From: Zac Denton <Zac.Denton@arun.gov.uk>
Sent: 12 November 2020 12:32
To: Planning.Responses <Planning.Responses@arun.gov.uk>
Subject: FW: EP/124/20/HH Little Dormers 23 Upper Drive BN16 1QN - Objection

From: Stephen Milliner [REDACTED]
Sent: 12 November 2020 11:39
To: Zac Denton <Zac.Denton@arun.gov.uk>; Planning <Planning@arun.gov.uk>
Subject: EP/124/20/HH Little Dormers 23 Upper Drive BN16 1QN - Objection

Garage Plans and Elevations -
Proposed

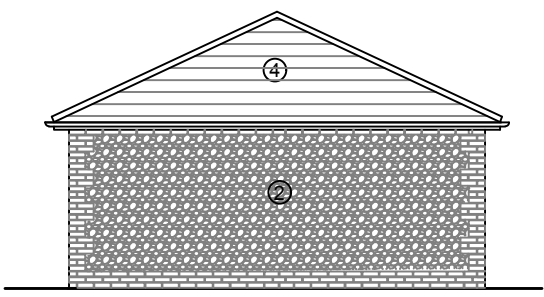
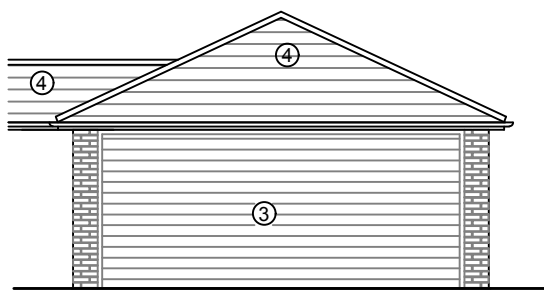
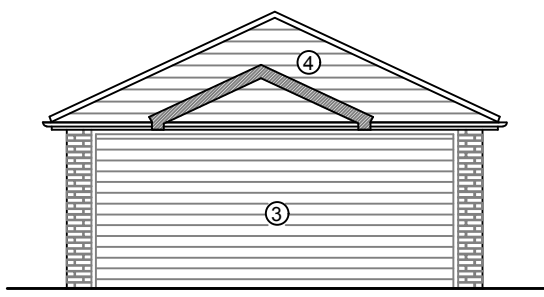
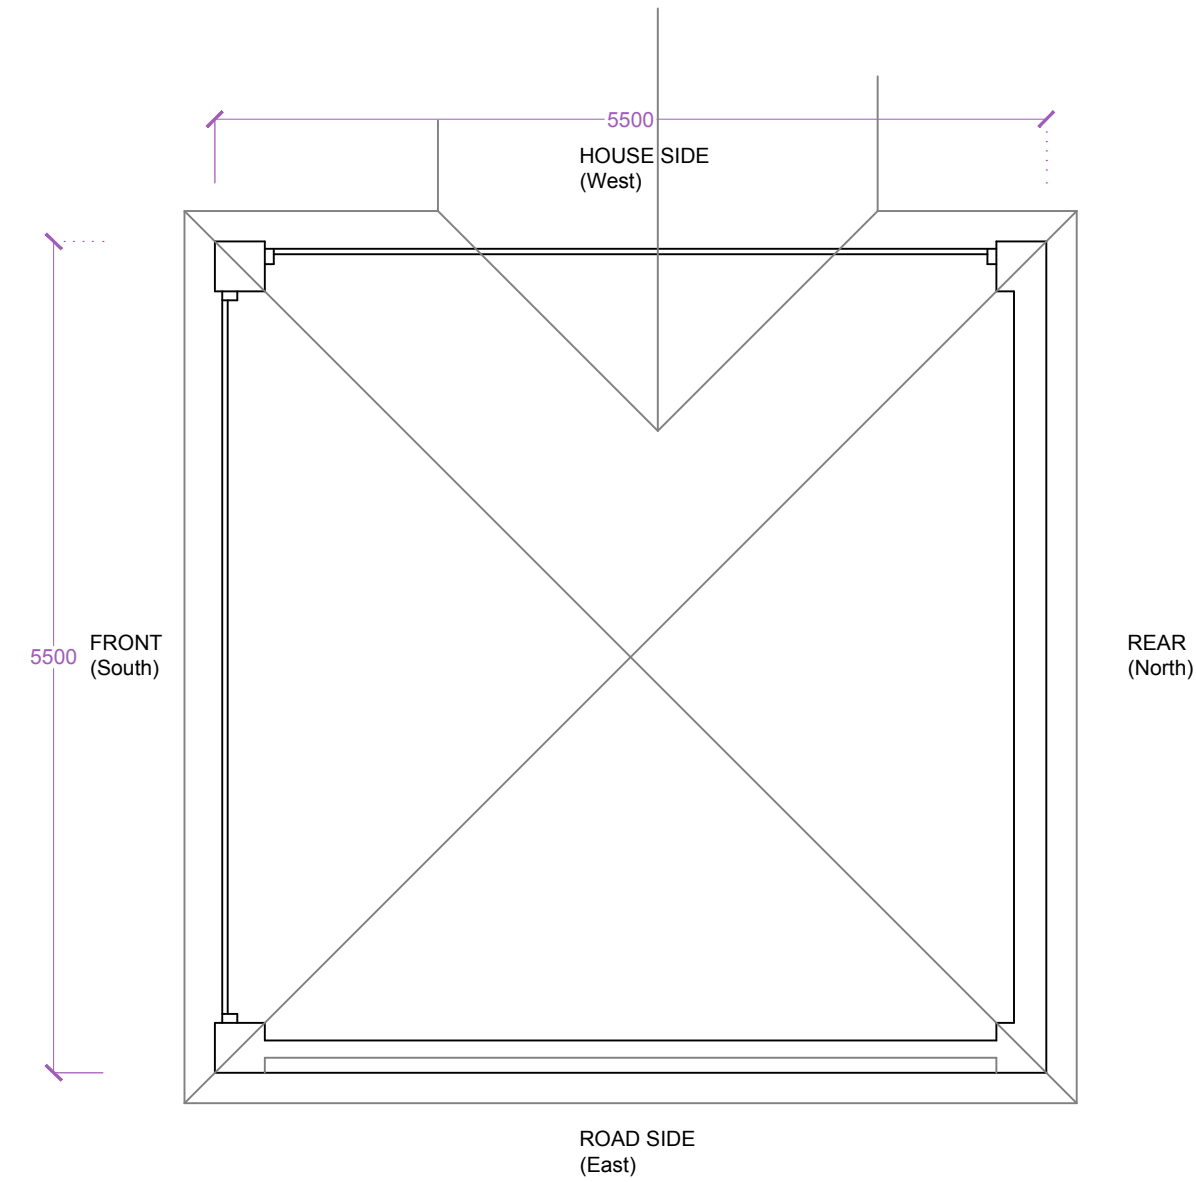
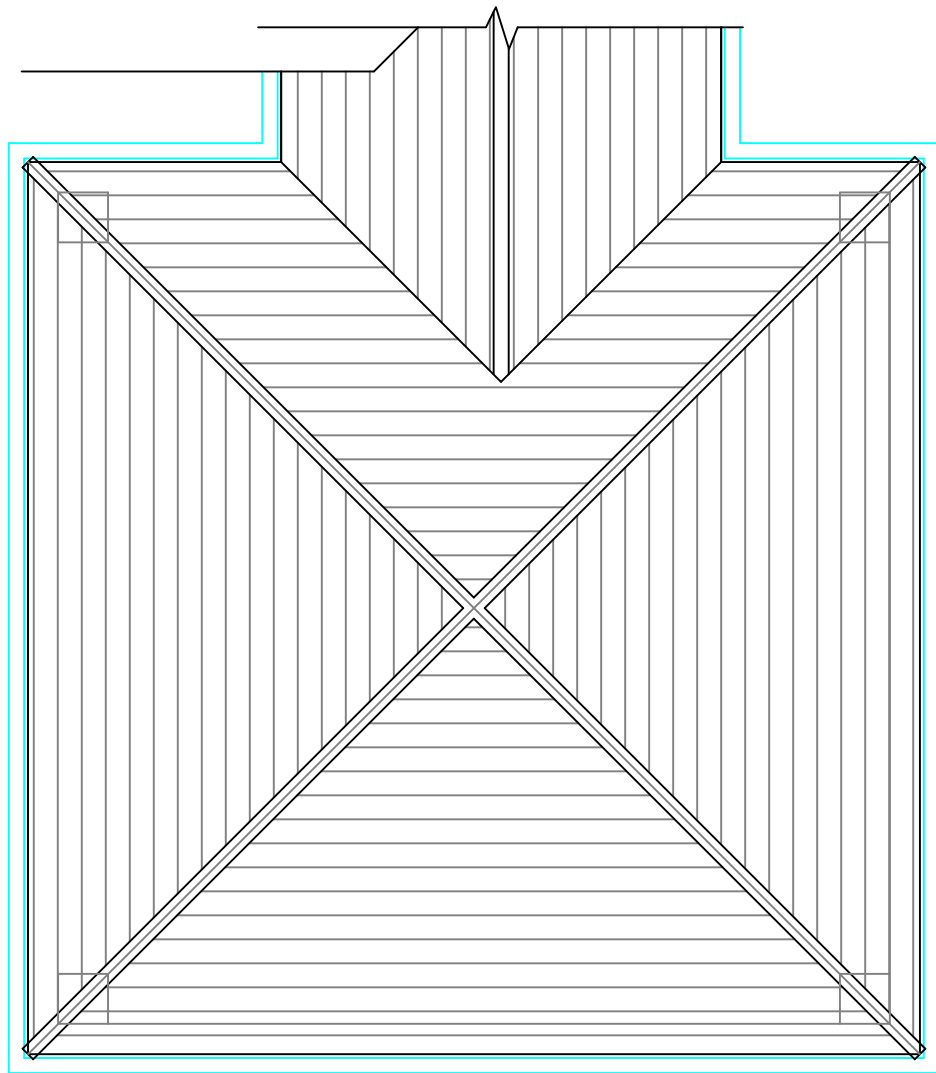
The new double garage front extension will be very close to the boundary of 25 Upper Drive and significantly block the view/transparency between buildings that currently exists. Such a transparent view between buildings is an integral part of the character of the Angmering on Sea Estate often described as the green garden estate.

The residents of 25 Upper Drive will have their front garden view derogated with a new relatively high garage immediately adjacent to their property and for just about the complete length of their front garden. Whilst the height of the garage is reduced from that shown on application EP/99/20/HH it is still significant in height and the overall plan area of the proposal has not reduced in significance so is still enormous and overbearing in front of the existing dwelling. The development does not reflect the spatial character and pattern of the street as required by policy D DM4 and derogates the visual amenity.

I am minded the extent and height of the proposed development may have a daylight/sunlight impact on the adjacent dwelling despite being lower than previously shown on application EP/99/20/HH. The proposed garage will be overpowering causing overshadowing of the adjacent property. Policy D DM4 requires an extension not to be overpowering and overshadow neighbouring properties and as such the proposal does not meet the requirements of D DM4.

I see the proposal has two garage doors on the new extension. This might be for access to the retained garage but there is a fear that these two doors could be open for significant periods of time and the garage used as a repair facility rather than for standard residential night time garaging of a motor vehicle. This could lead to a further derogation of the visual amenity plus noise nuisance. It would be a shame if a workshop appearance is presented on a leafy residential road. Similarly, if the west facing garage door is open the occupants of 25 Upper Drive will be looking in to a garage when the west door is open rather than the leafy street scene they currently enjoy and although the applicant has now indicated there will be a fence on the north boundary such fence cannot be guaranteed to be in place for ever unless conditioned to remain in place in perpetuity.

The covered open sided link connection between the existing garage and the new garage combined with the location of the new garage is likely to cause a wind tunnel effect and southerly winds are likely to cause increased wind speeds at the frontage of 25 Upper Drive. This effect can be very disconcerting particularly for elderly people and in some instances completely intolerable although this application now shows a fence on the north side of the development which should suppress such effects at low level.

That those parts of the proposal shown as garage space are used for garage/parking space only in perpetuity and any permitted development rights for the new development are extinguished. This is to avoid a change of use to further living accommodation increasing the likelihood of offsite parking.
